January 6, 2022
File No. 21-004.200

Subject: Response to Geotechnical Review Comments
9611 SE72nd Street
Mercer Island, WA

This letter provides geotechnical responses to the document 211216 Geotech Comments, the geotechnical plan review comments from the City of Mercer Island, and provides recommendations for addressing the City's review comments.

Geotechnical Addendum
9611 SE 72nd Street
Mercer Island, Washington
January 6, 2022

SHEET TITLE:
Shoring Plan

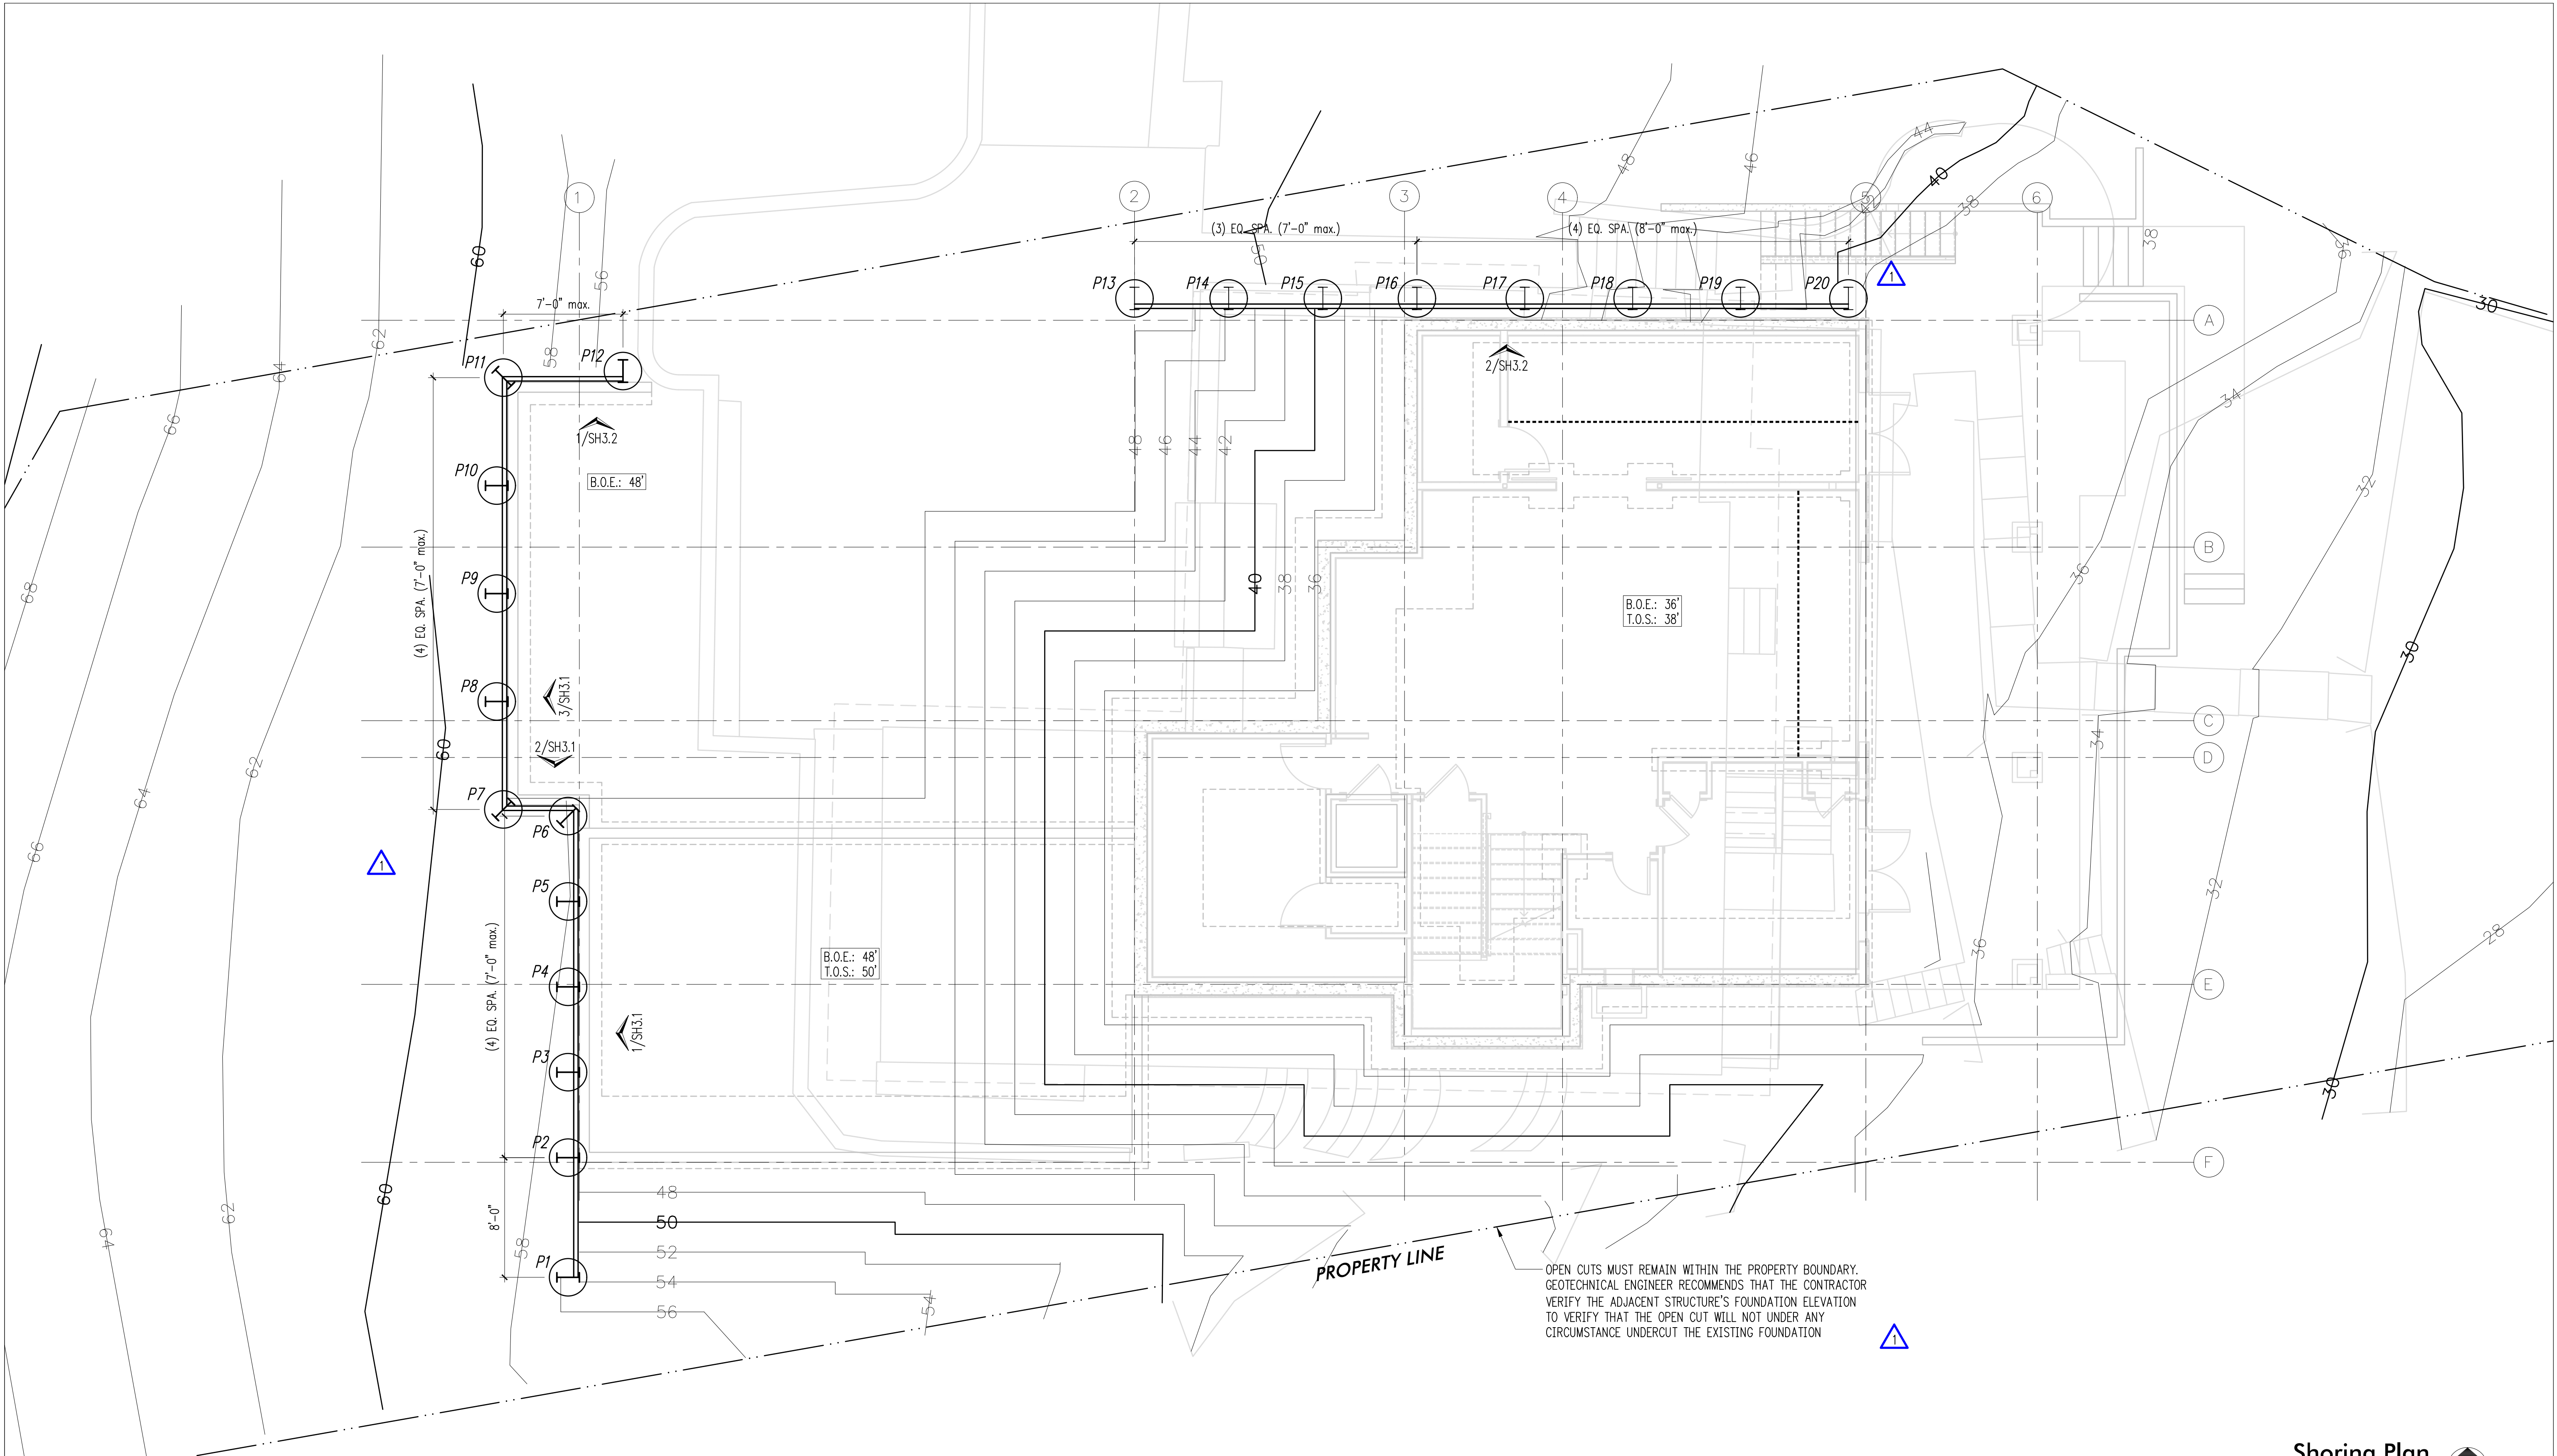
that the soldier pile wall is constructed as per plan and that the recommendations presented in our report are properly incorporated into the design and construction of the project. The City of Mercer Island does not show any identified landslides on the subject site; however, the Washington Department of Natural Resources maps the area below East Mercer Way as a pre-historic slide area, based on Lidar assessment, and the slope is mapped as mantled with mass wasting deposits. In our opinion, the slope area is currently inactive, and catchment provisions are not required. As a precautionary measure, the soldier pile wall may be designed with 1 foot of catchment to control any potential soil creep.

Per our geotechnical report dated September 7, 2021, we recommend shoring along the south side of the excavation. In the cut for the garage, it may be more effective to add 2 or 3 soldier piles along the south side. In general, cuts less than 5 feet in height and cuts in the hard clay may be retained with UltrablockTM walls, per our report. We also recommend that, prior to any construction, a survey be taken of the house structure to the south, and that temporary monitoring points be established on the house adjacent to the excavation. These points should be surveyed weekly during the time the excavation is open, and the results should be forwarded to us for review. The elevation of the foundations of the adjoining house should be confirmed and considered in planning open cuts and shoring.

Our report of September 7, 2021, recommended permanent soldier pile walls above the driveway with weepholes for drainage. The weepholes should be designed and installed

to prevent piping of soil behind the wall. Soldier pile walls constructed against concrete foundations, such as above the garage, should be provided with drainage strips. These should be connected to a drainage system separate from the foundation footing drain and discharge at an approved discharge point.
